SSD 6917: OAKDALE SOUTH – S.96(1A) APPLICATION TO CONCEPT PLAN TO INCLUE E2 / IN1 ZONE UPDATE ON LOT 3A

I write on behalf of Goodman, the applicant to SSD 6917 (Oakdale South Industrial Estate (OSE)), to lodge an application under S.96(1A) of the Environmental Planning and Assessment Act 1979 (the Act), for a modification involving minimal environmental impact.

This S.96(1A) application seeks to update the approved concept plans to replace a corner landscape, E2 zone in Lot 3A, OSE with hardstand, IN1 zone. This update corresponds with:

E2 Zoning Boundary
Current ———
Proposed - - - - -

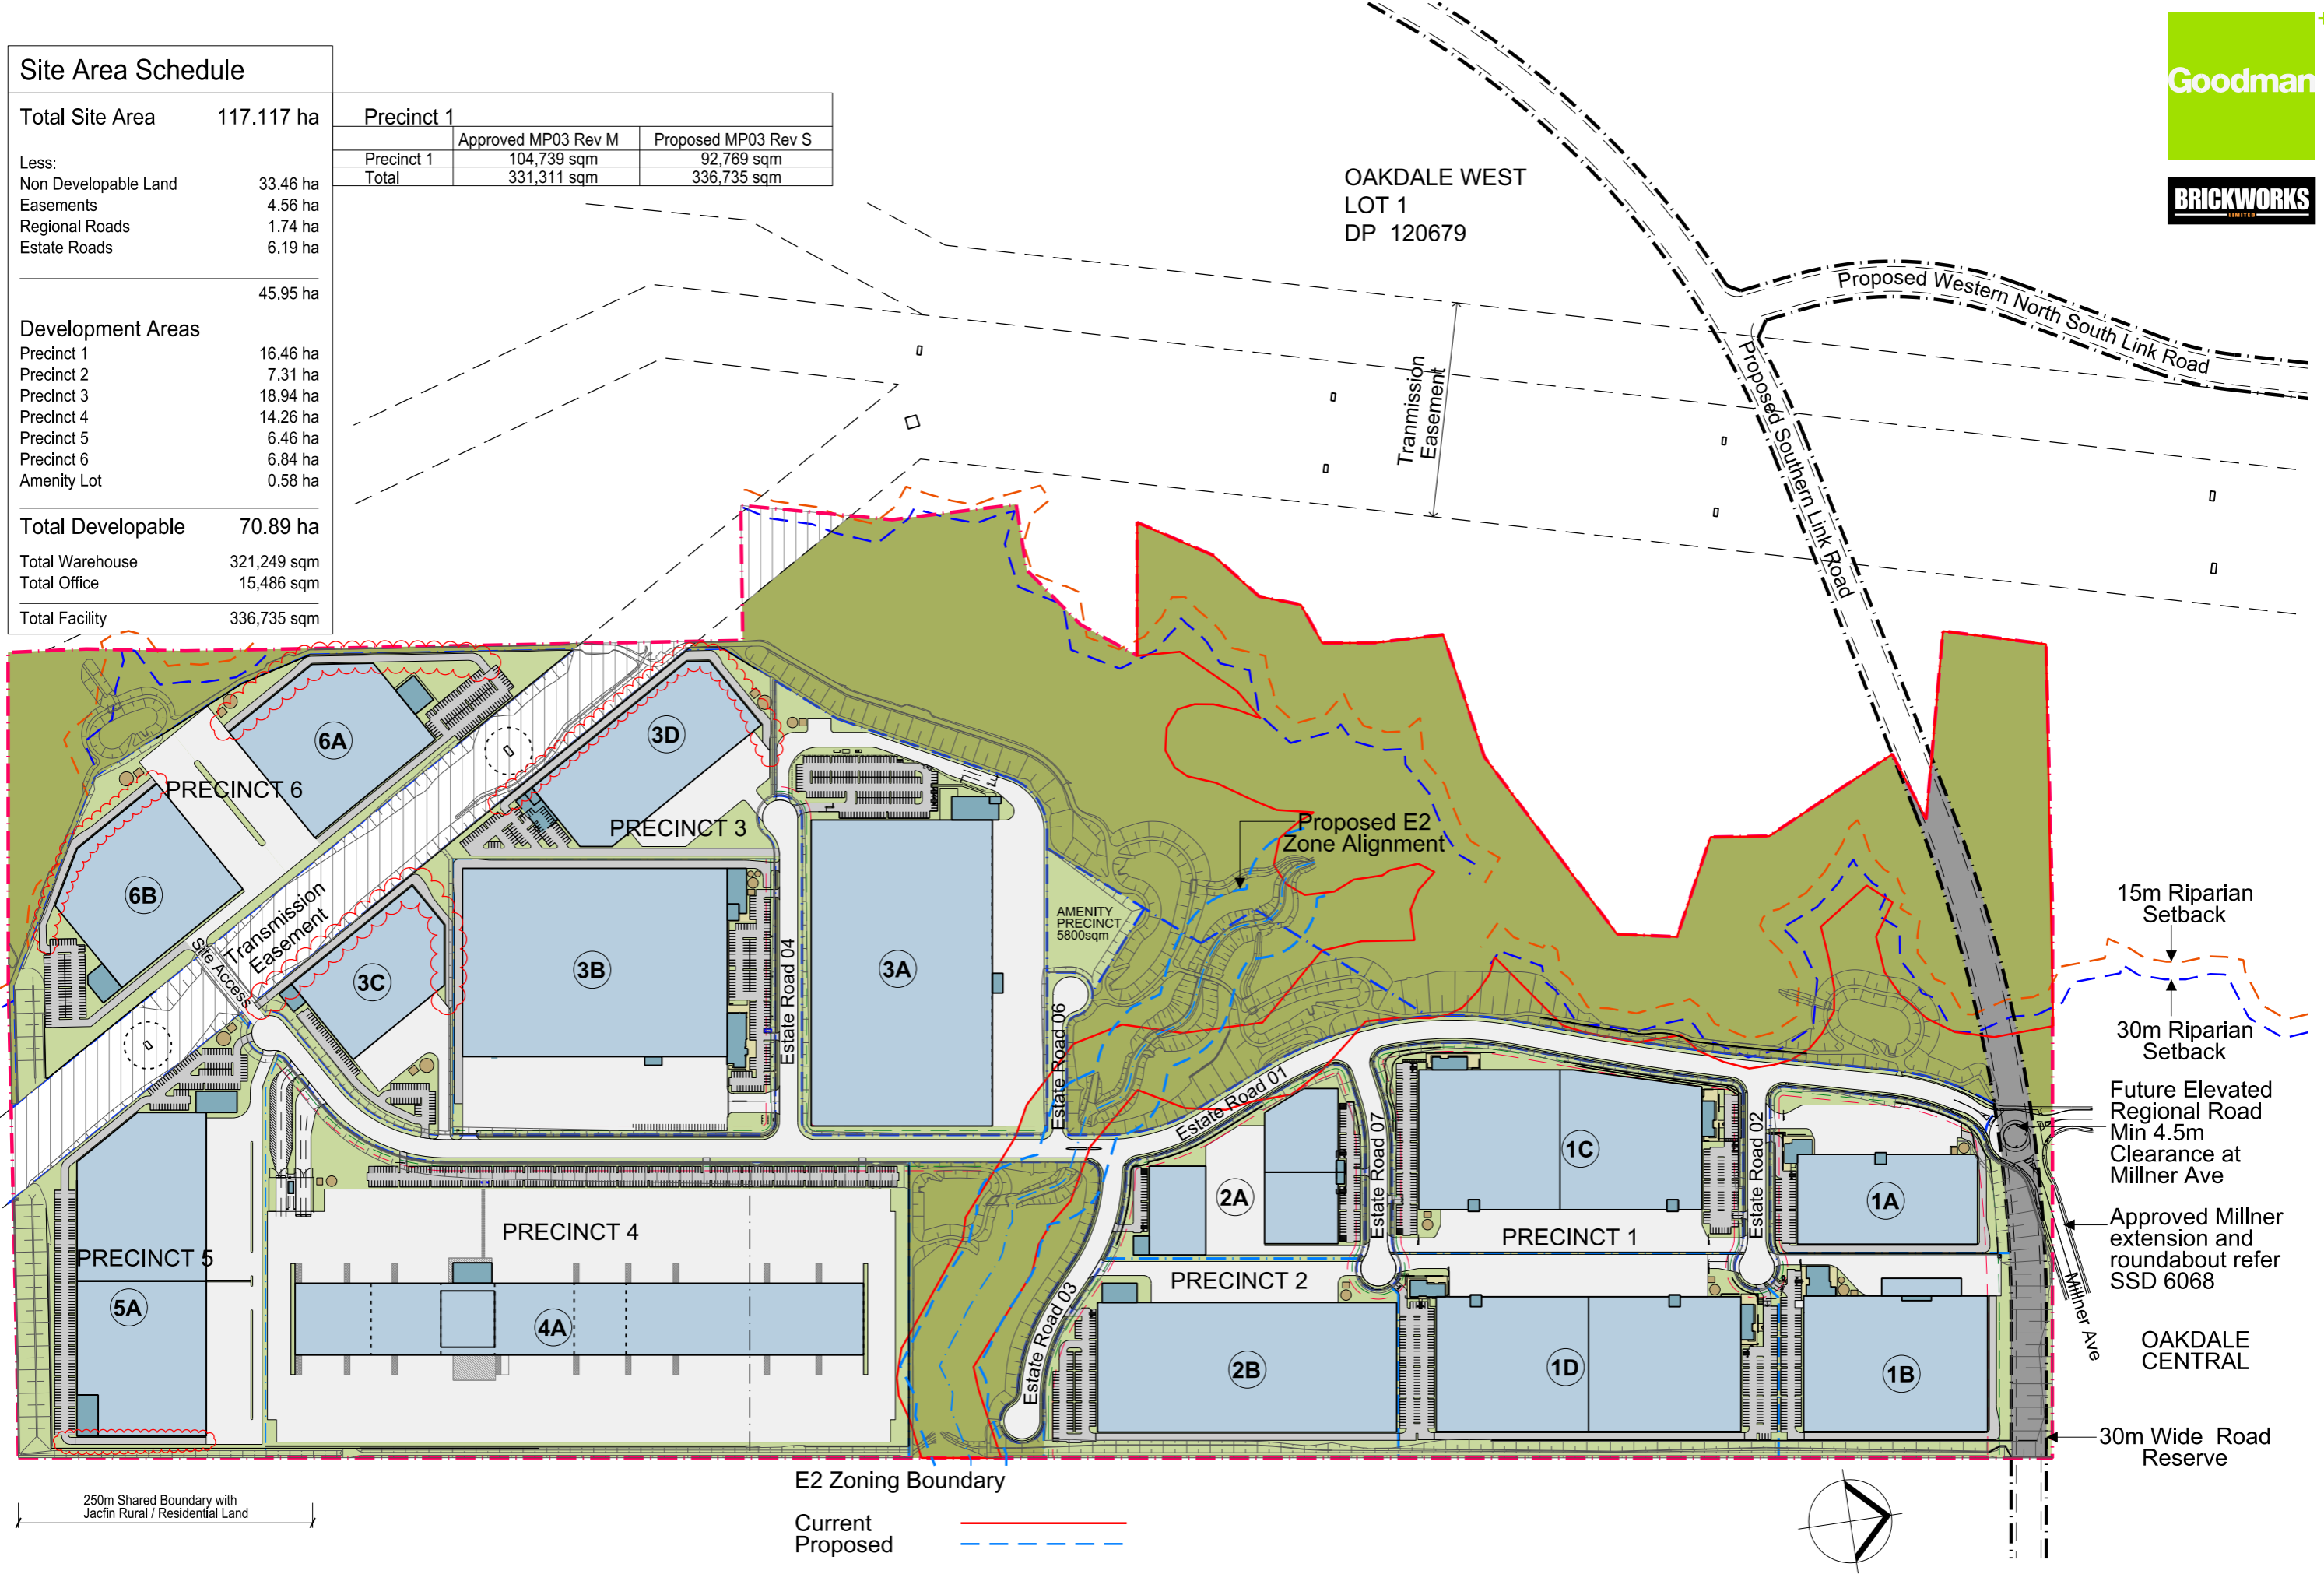
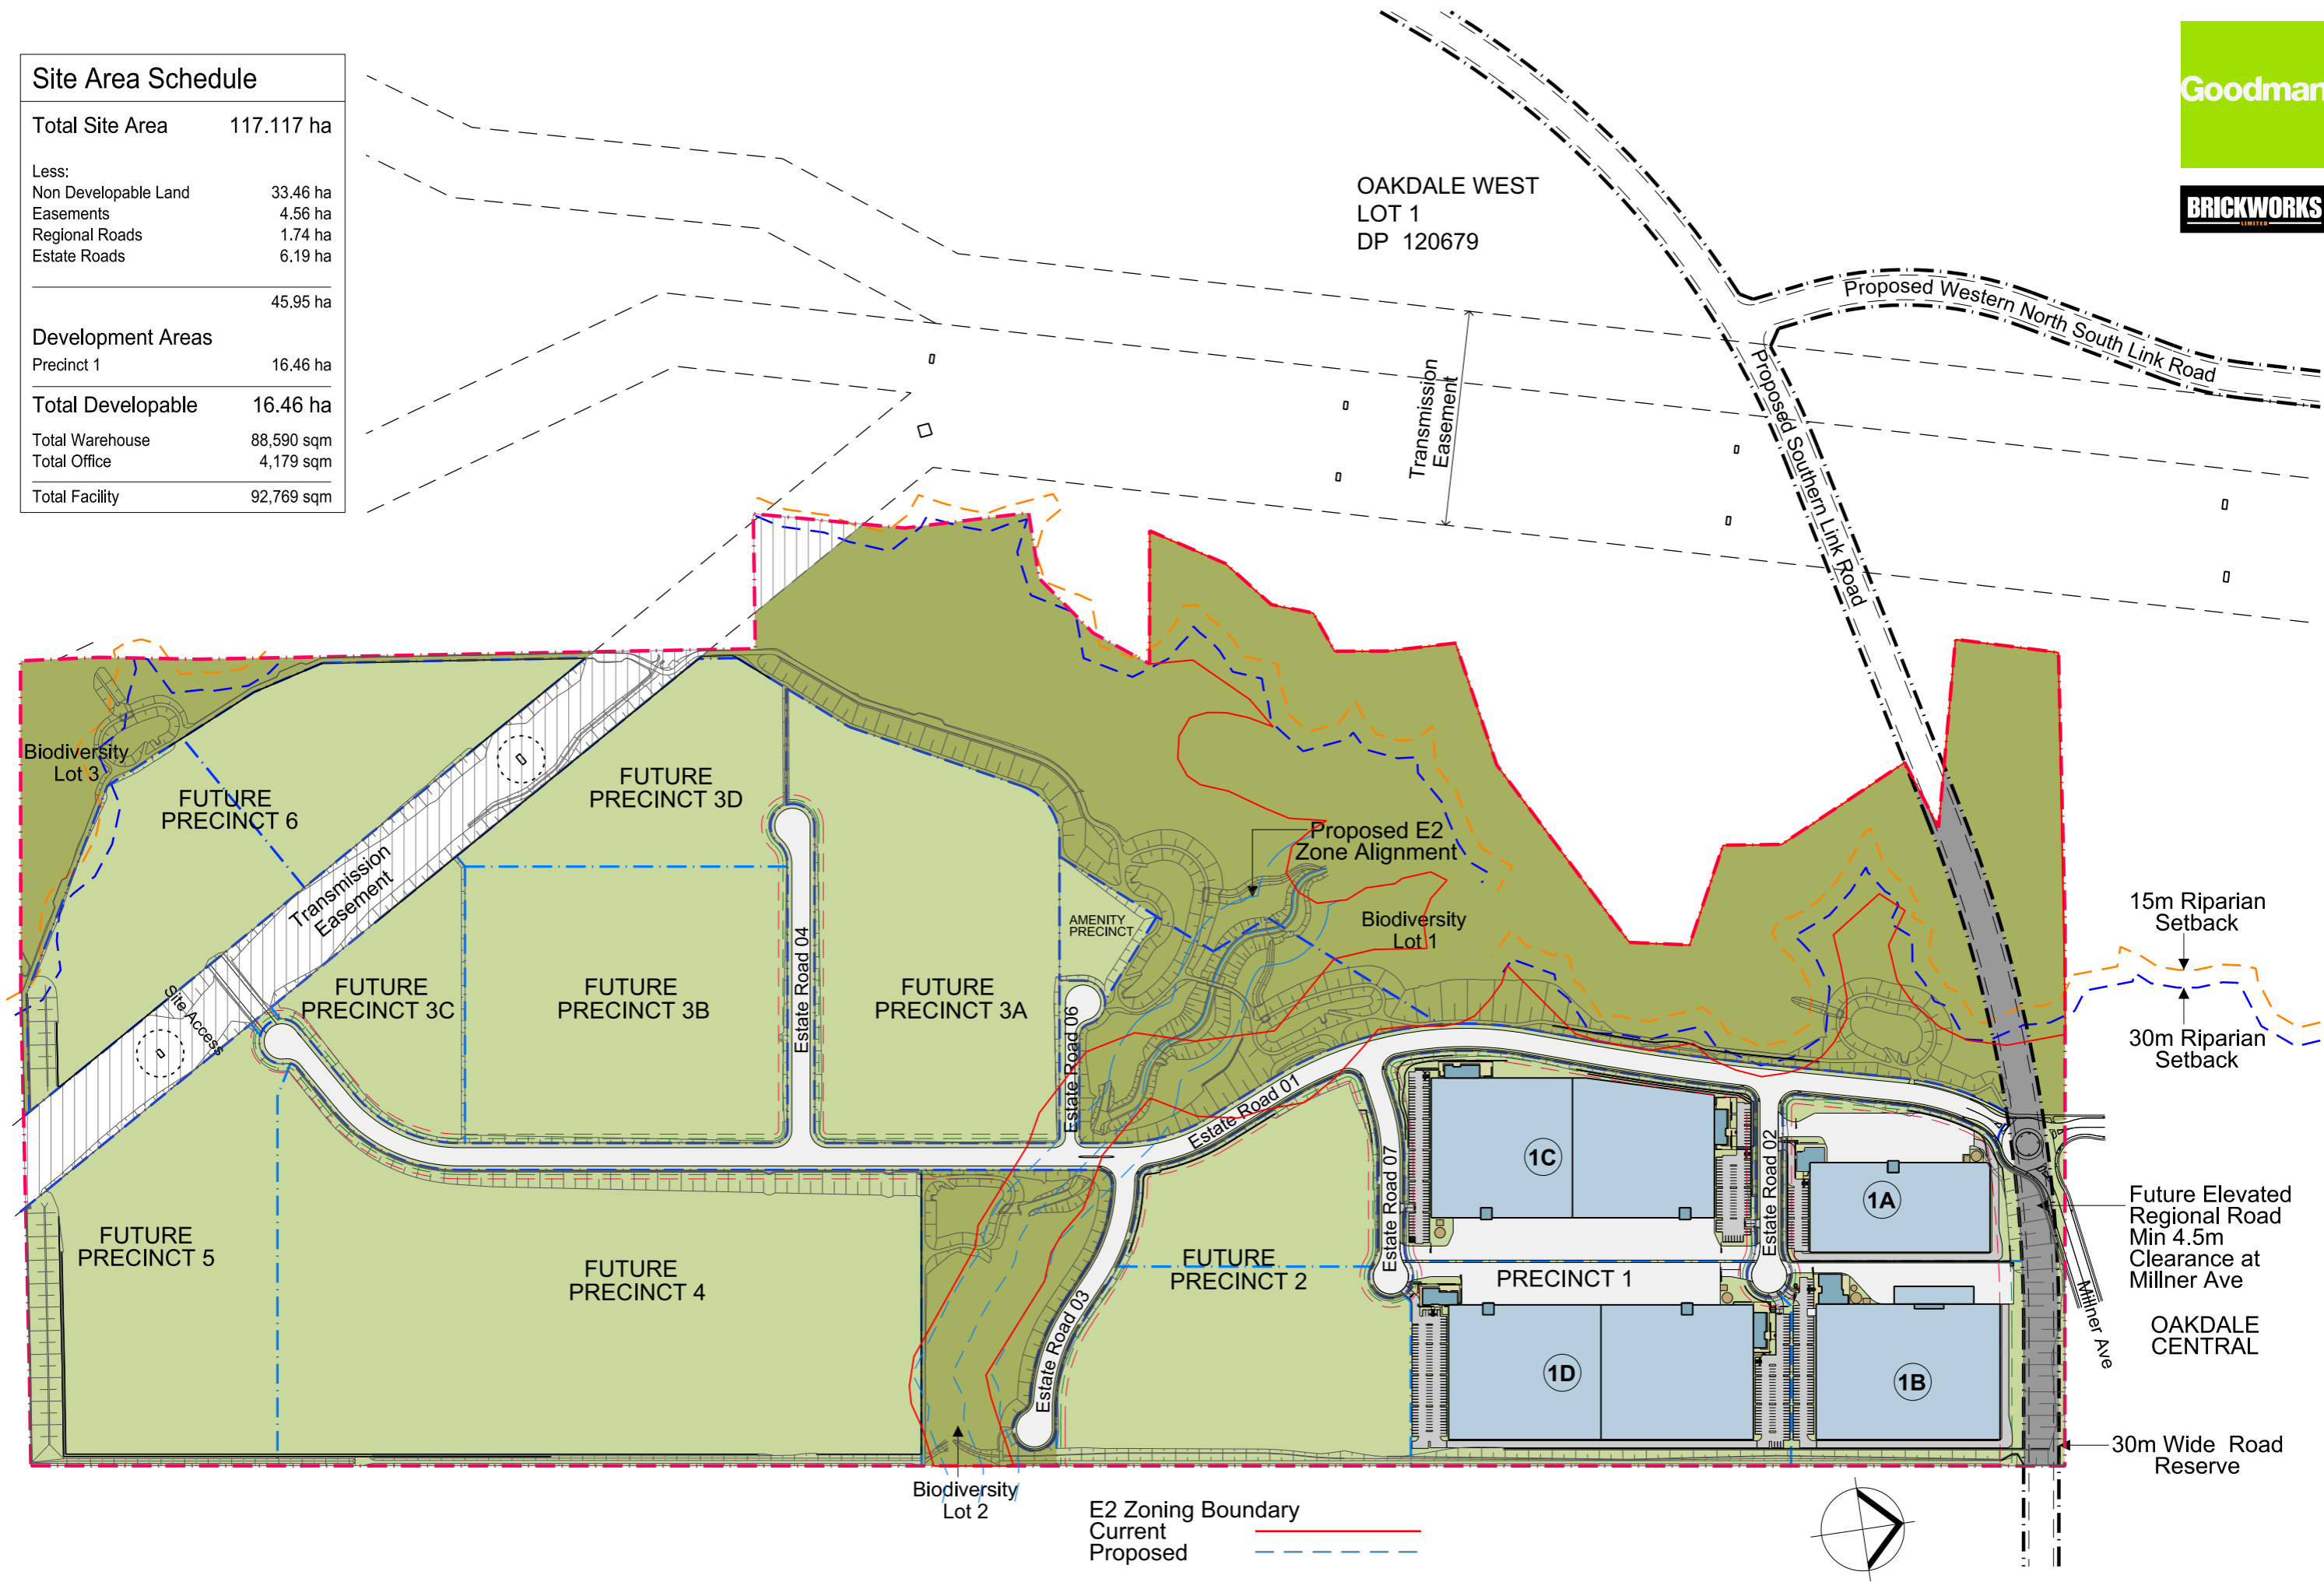
This application seeks to update relevant concept plans to remove E2 zone in the corner of the Lot 3A, replacing it with IN1 zoned land. This ensures consistency with that of the impending E2 / IN1 rezoning and SSD 7719 S.96(1A) plan update.

The updates will require update of the following architecture and landscape plans:

| Master Plan Drawings prepared by SBA Architects | | | |
|---|---------------------|--|--------------------------|
| OAK MP 02 | RR SS | SSDA Masterplan | 17/10/2017 09/02/2018 |
